Appendix B – EPA document DCO17/474816-02
dated 17 October 2017

- ENVIRONMENT PROTECTION AUTHORITY COMMENTS -

SSD 8344 KELLYVILLE NORTH PUBLIC SCHOOL EIS

Noise level charts Tuesday 30 May 2017

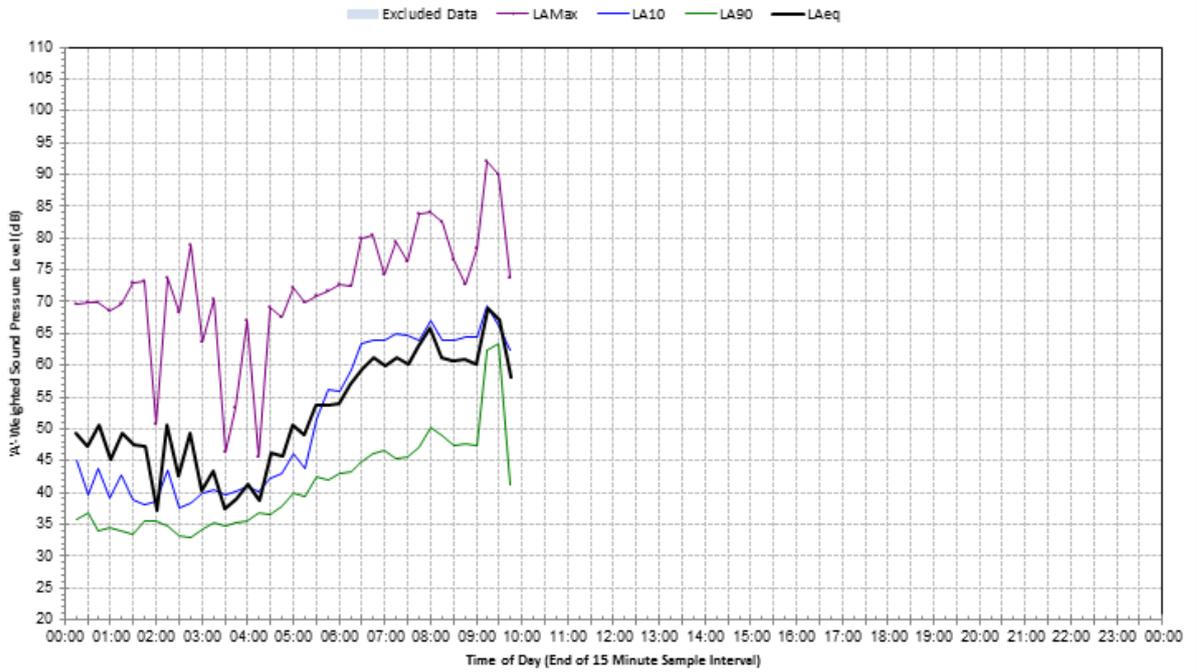
The proponent has not obtained a 'week's worth' of valid data from which to derive daytime background noise levels. In particular, the logger data graphs in Appendix A to the Acoustic Report for Tuesday 23 May and Tuesday 30 May 2017 show that –

- only a small amount of data was collected for these daytime periods, and
- that data appears to be adversely affected by setup and retrieval noise.

The EPA notes that the Assessment Background Levels (ABLs) for both Tuesdays is markedly higher than for other days and should be excluded from the Rating Background Level (RBL) calculation. And thus, results in an RBL of 36 dBA, which should apply to both daytime and evening assessment periods.

The proponent be required to either –

- (a) re-measure background noise levels, and measure representative noise levels for the area in accordance with the guidance material in the Industrial Noise Policy, or
- (b) adopt a background noise level of 36 dB(A) and a Project Specific Noise level (PSNL) of 41 dB(A) for the day time and evening assessment periods.
